May 12, 2021

**RE: Bradley Heights PUD Development Plan – Initial Review Comments**  
**File # AR PUD 21-00206**

The proposed project involves a PUD development plan to enable development of a vacant parcel into 168 single-family residences. Staff finds that the application is largely acceptable; however, the following technical modifications must be completed.

SMALL LOT PUD DEVELOPMENT PLAN
PRELIMINARY GRADING PLAN - SOUTH

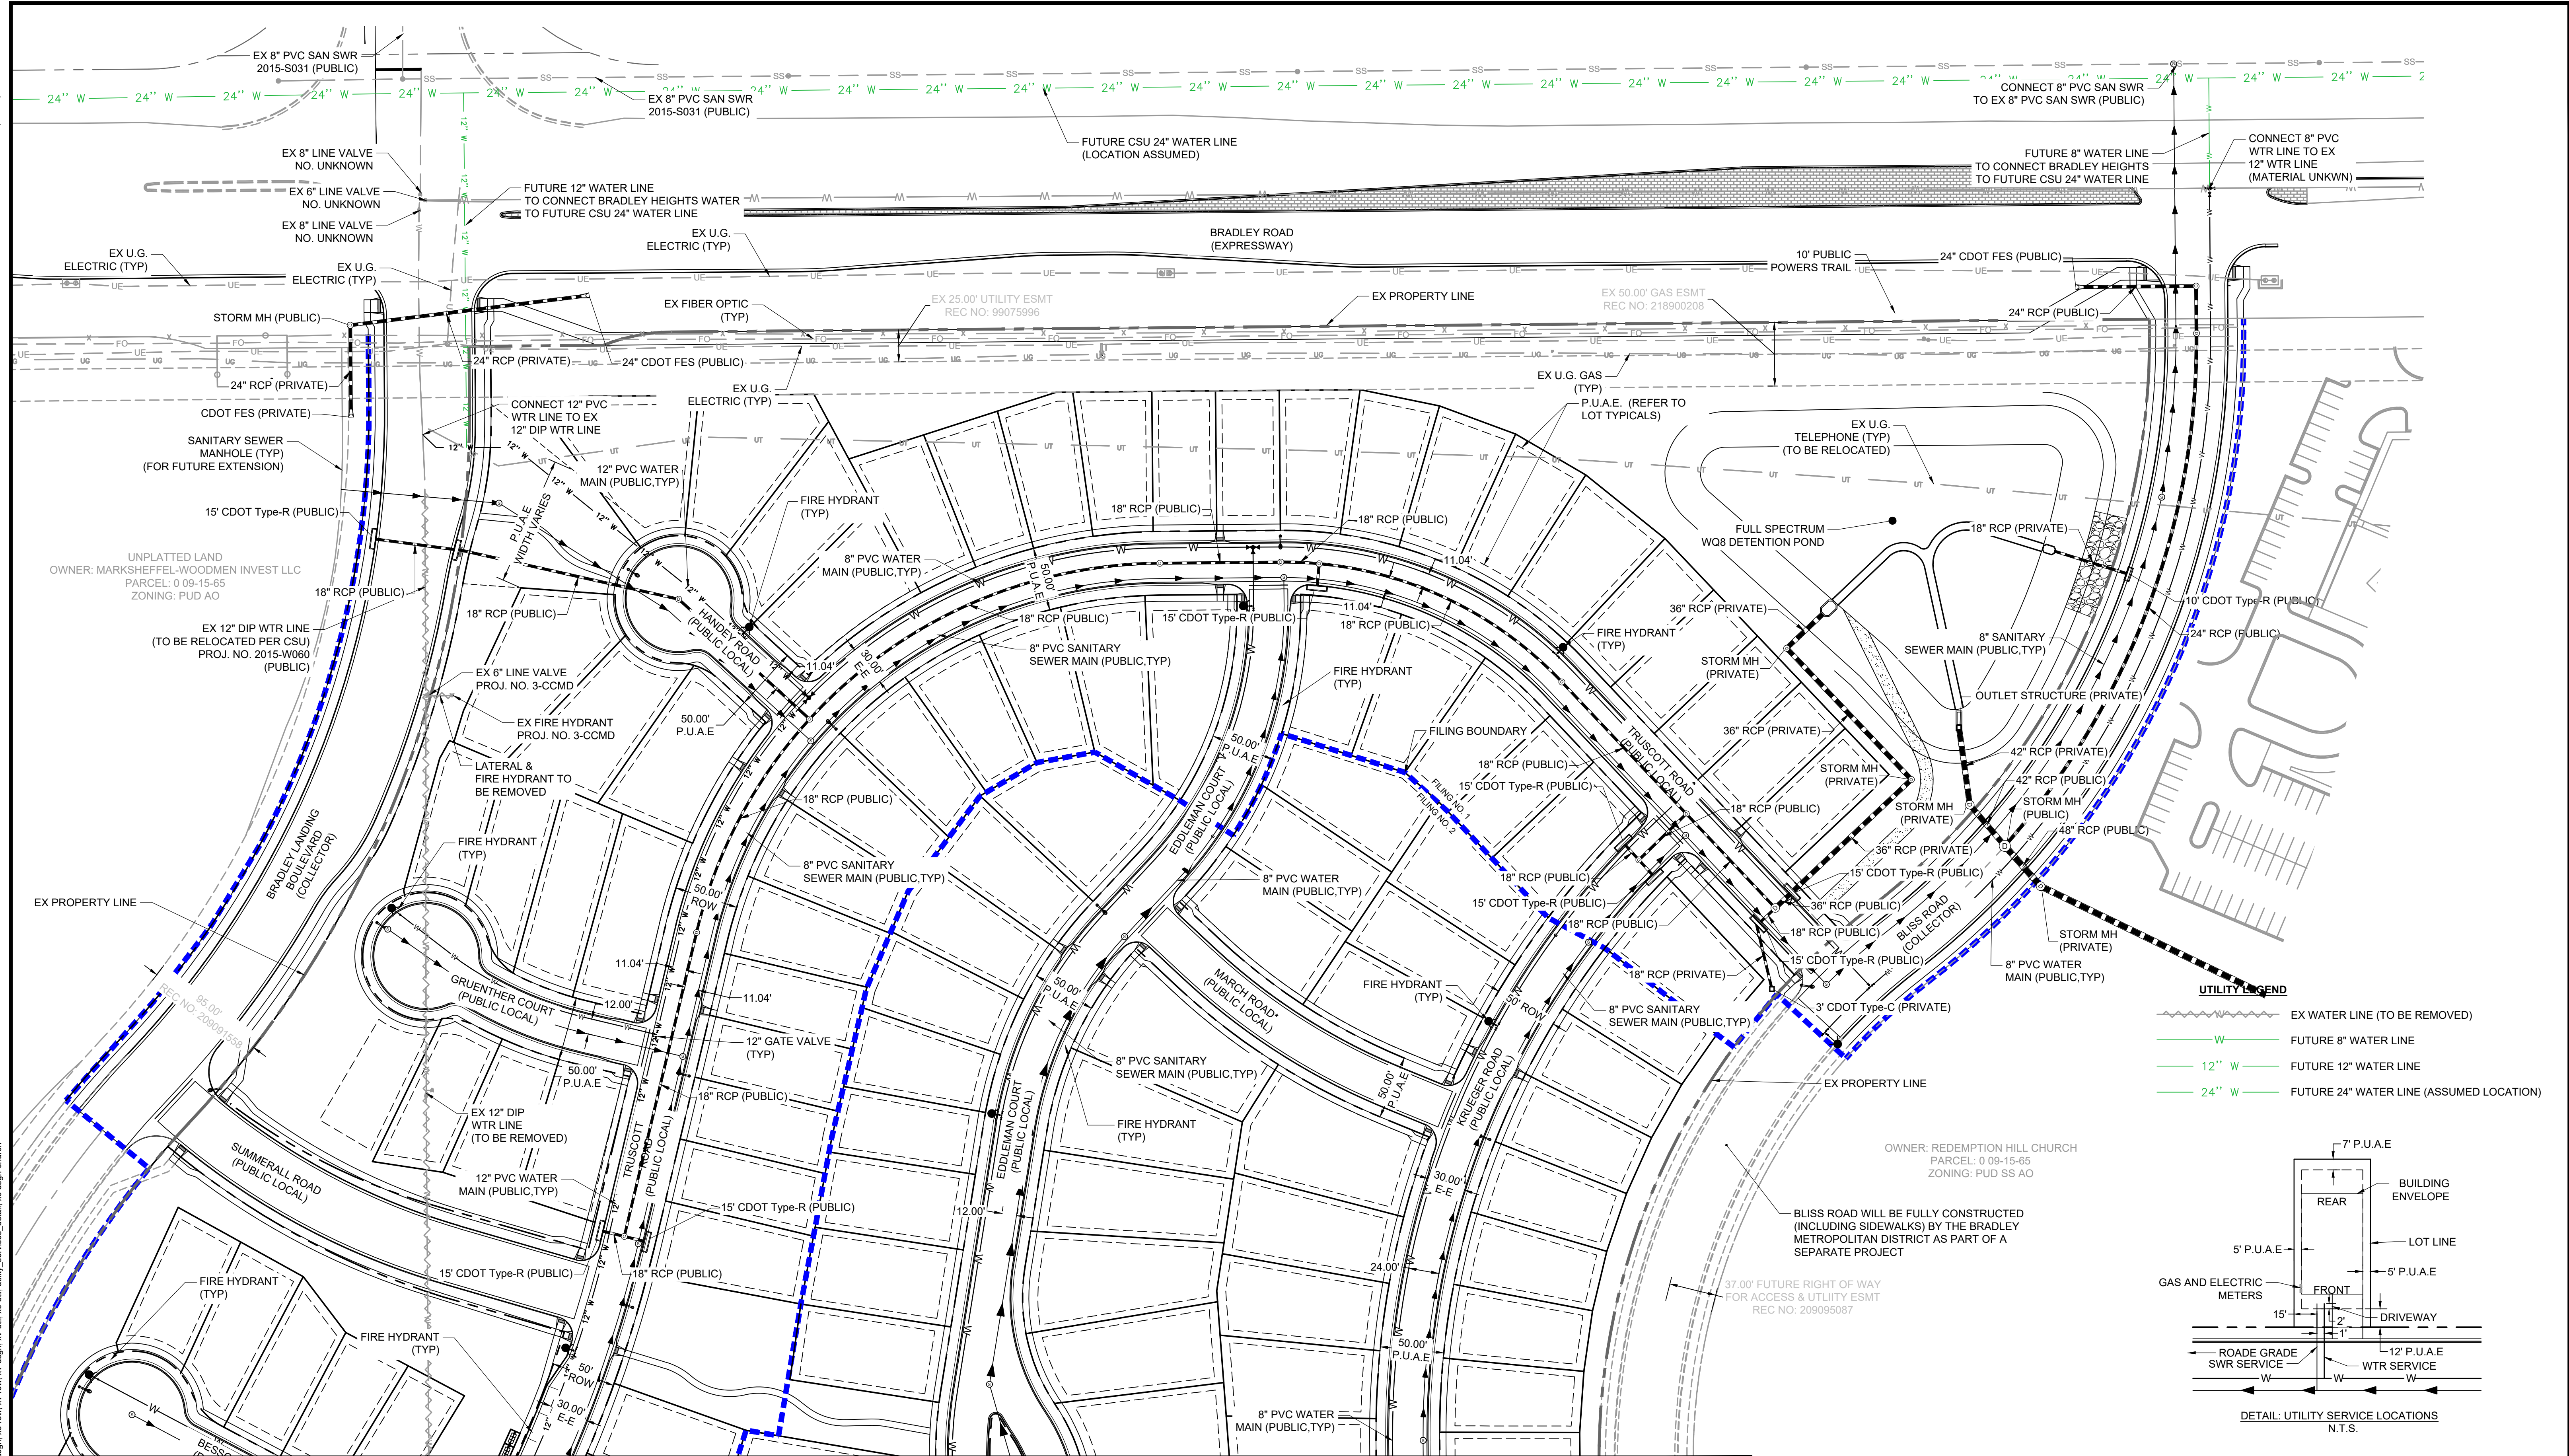
5. Remove note on sheets 4 and 5 stating minimum driveway length is 15 feet. Minimum must be 20 feet.
6. Confirm whether any retaining walls are to be utilized? If so, show on grading plan and denote T.O.W. and B.O.W.

14. Provide dimensions for the width of common area tracts on the site plan.
15. Please show any retaining walls on grading plan and landscape plans, and identify TOW and BOW measurements for all.
